Application for approval of matters reserved by condition imposed under AL/47/14/PL relating to condition No. 6 (Landscaping scheme), 7 (Plot boundary fences), 8 (Surface water drainage), 9 (Scheme to improve current site access) & 10 (Lighting)

Aldingbourne Farm Shop Nyton Road Aldingbourne

Thank you for your internet representation made on 26th April 2017 which has been recorded as '**an objection**' with the comments as follows:

Appendix 5

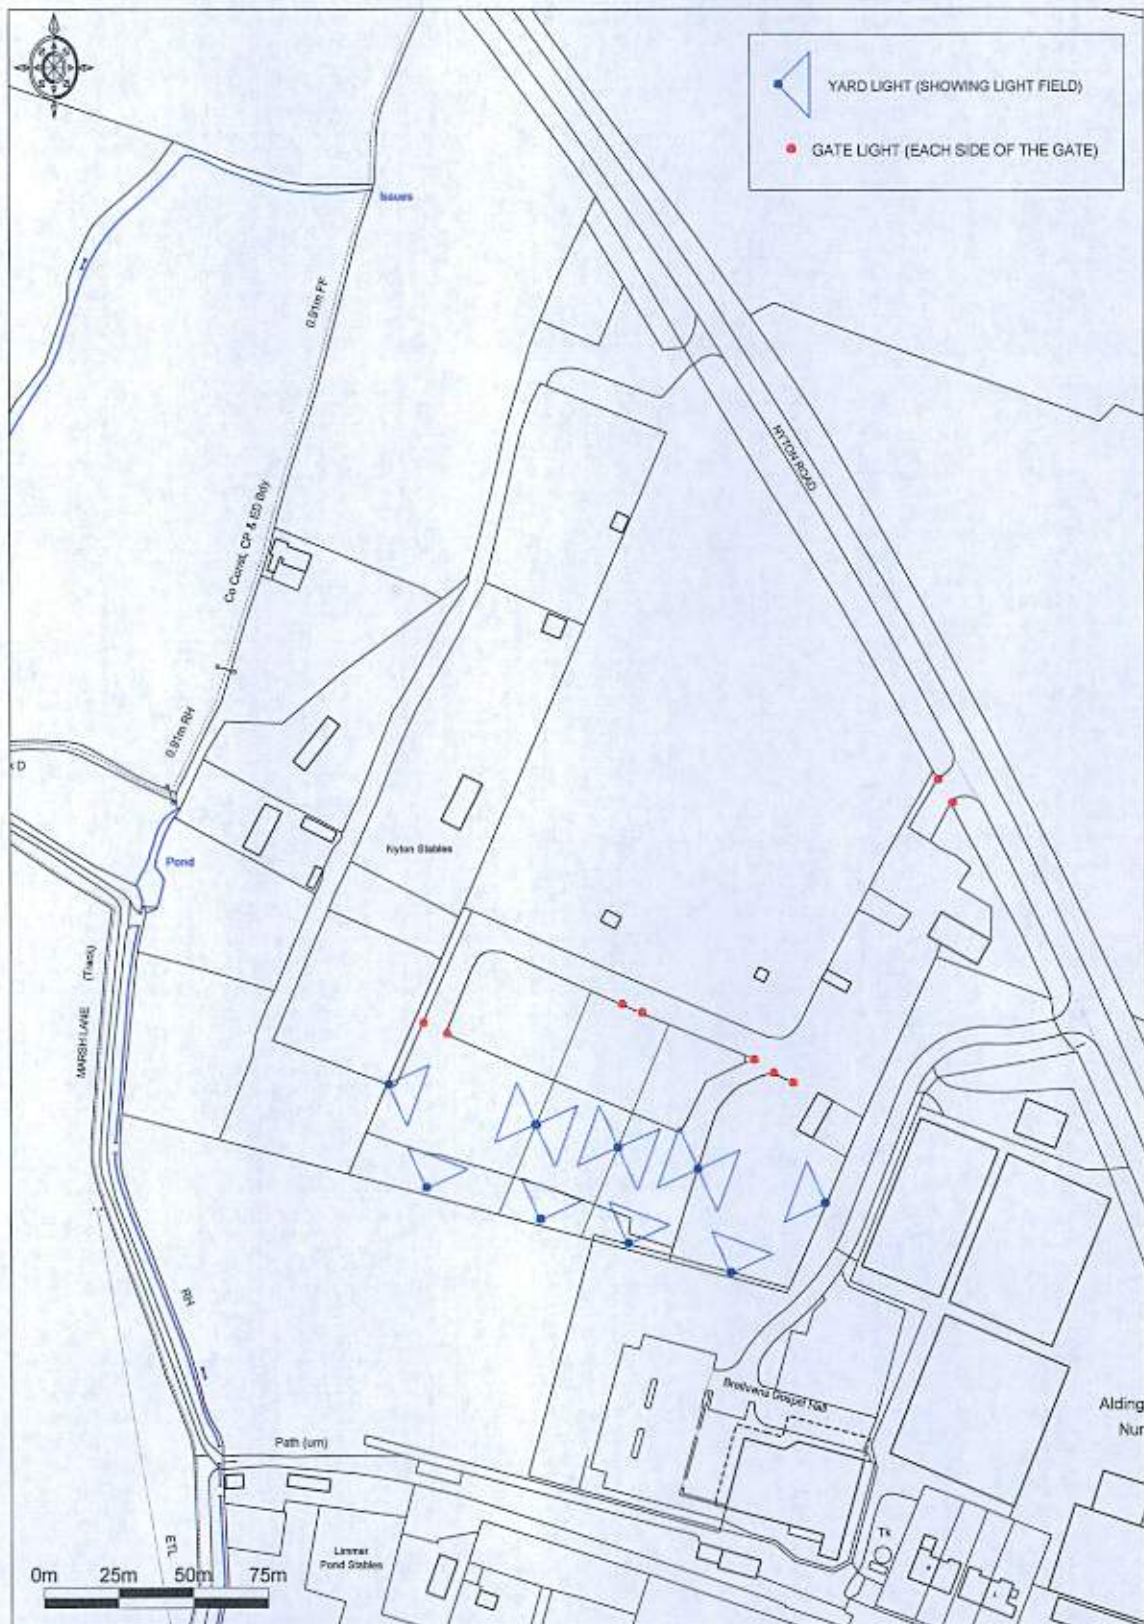
We object to the flood lights and under eaves lights as shown on Appendix 5., due to the invasive nature of such lighting on our location. When lighting was considered it was to be no higher than 1m, which should be sufficient. The reason for emergencies services access is not acceptable as the majority of rural areas have neither street lighting or flood lights. The number of flood lights proposed is far in excess of what would be reasonable (8 numbered in the literature and 9 in the drawing) and necessary. The original permission stated fence lighting at a maximum height of 1m (AL/47/14/PL), therefore even the under eaves lighting would breach this condition, as the homes are raised a metre off the ground before the calculations can even begin.
